**From:** [REDACTED]  
**To:** [Cleve Hill Solar Park](#)  
**Subject:** Cleve Hill Solar Park EN010085 Ref 20018862 - Objection ACL report - Oral presentation summary  
**Date:** 31 July 2019 22:10:28

**Cleve Hill Solar Park Development – Agricultural Land Classification – Objections – Summary of Oral Presentation on Tuesday, 16<sup>th</sup> July 2019**

Date: 22/03/2017

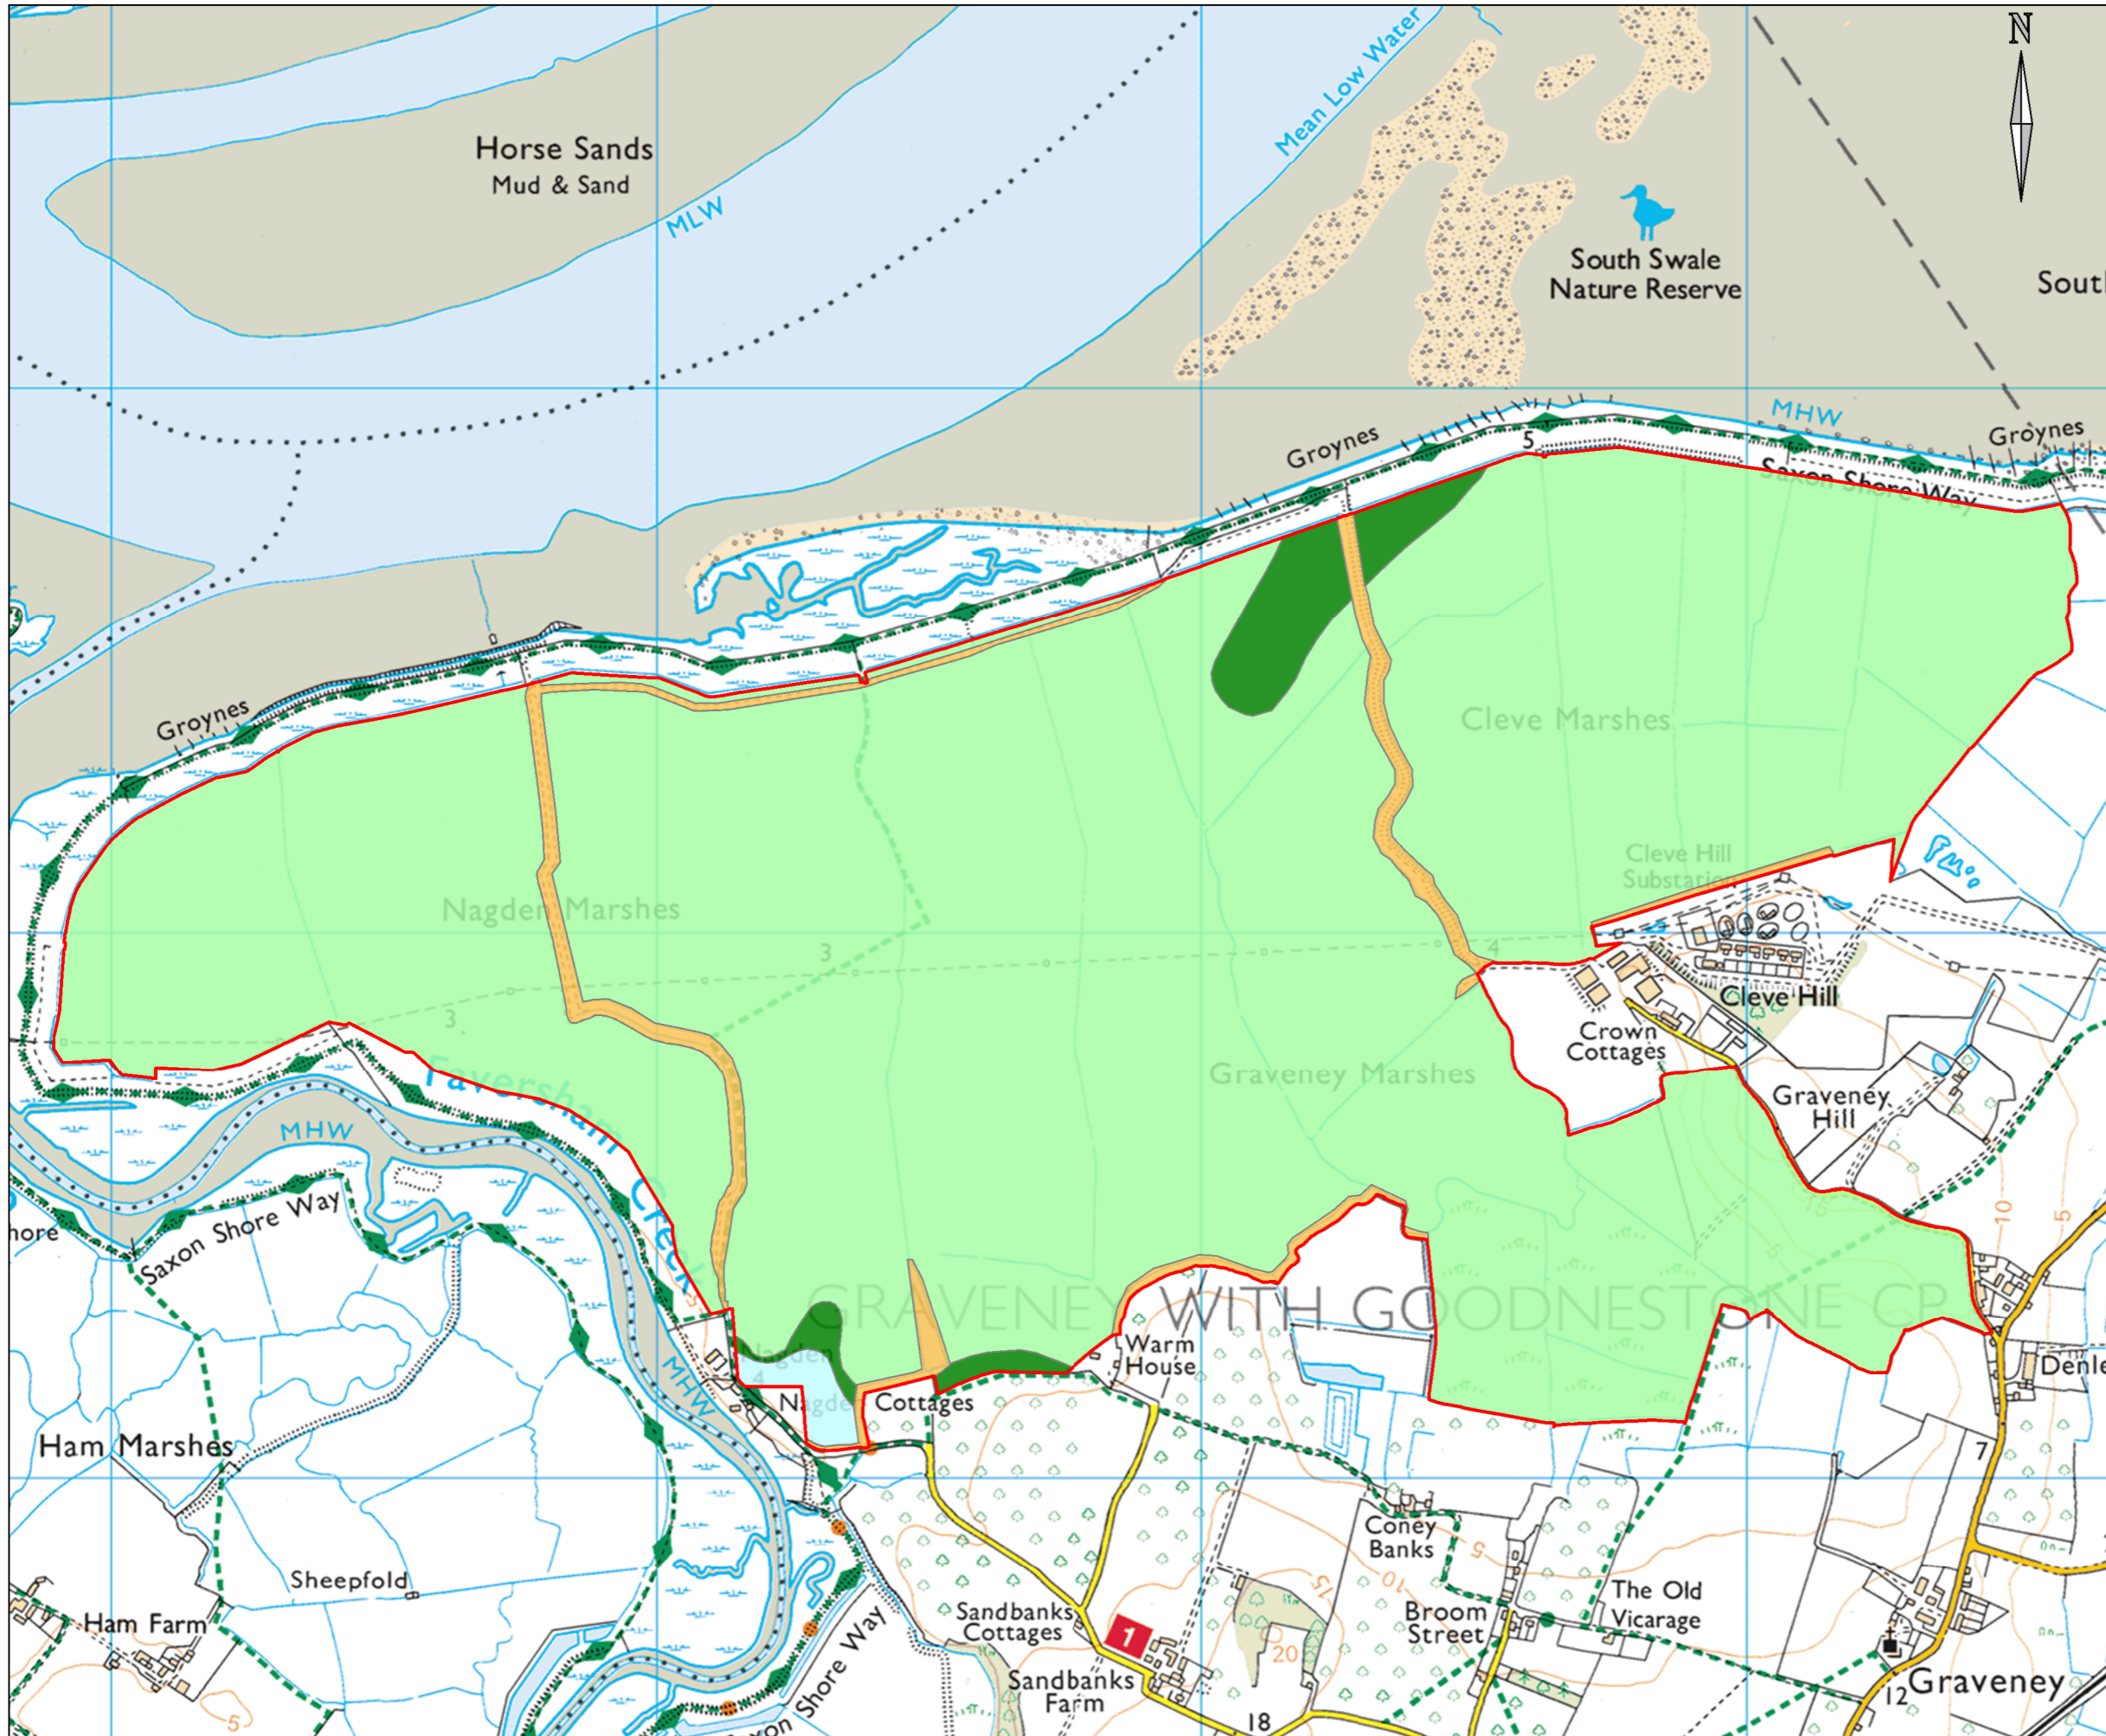
However, by a more detailed assessment of the field observation presented in the same report, I noted that the ALC report did in fact not follow the MAFF 1988 guidelines. I also stated that the field survey was 'biased' in relation to being undertaken at the time of year following an extremely wet February 2017 followed by two weeks of rainfall during the duration of the field survey at the beginning of March 2017.

I also mentioned that the report was incomplete and had missing data and that some assessment criteria to determine Wetness Class for two observation locations have been incorrectly interpreted.

I detailed that a large number of observation points have been entirely incorrectly interpreted in accordance with MAFF 1988 guidelines based on the presence of calcium carbonate in the soils. As each field survey sampling point was equivalent to about 2 ha of land, a considerable percentage of land could be reclassified as Grade 3a based on this fact alone.

I detailed that no quantitative data (as defined by the MAFF 1988 guidelines) has been presented in the report demonstrating that the soils at the site are water logged for the duration of more than 91-180 days.

I made reference to a local metrological monitoring station in close proximity to Cleve Hill Farm. I stated that I re-evaluated the Wetness Class across the site, based on actual and local metrological data and considering that a large part of the land has naturally calcareous soils, it was my opinion that over 75% of the land at Cleve Hill Farm can be graded as Grade 2 (very good agricultural land) and Subgrade 3a (good agricultural land) in accordance with MAFF 1988 guidelines.
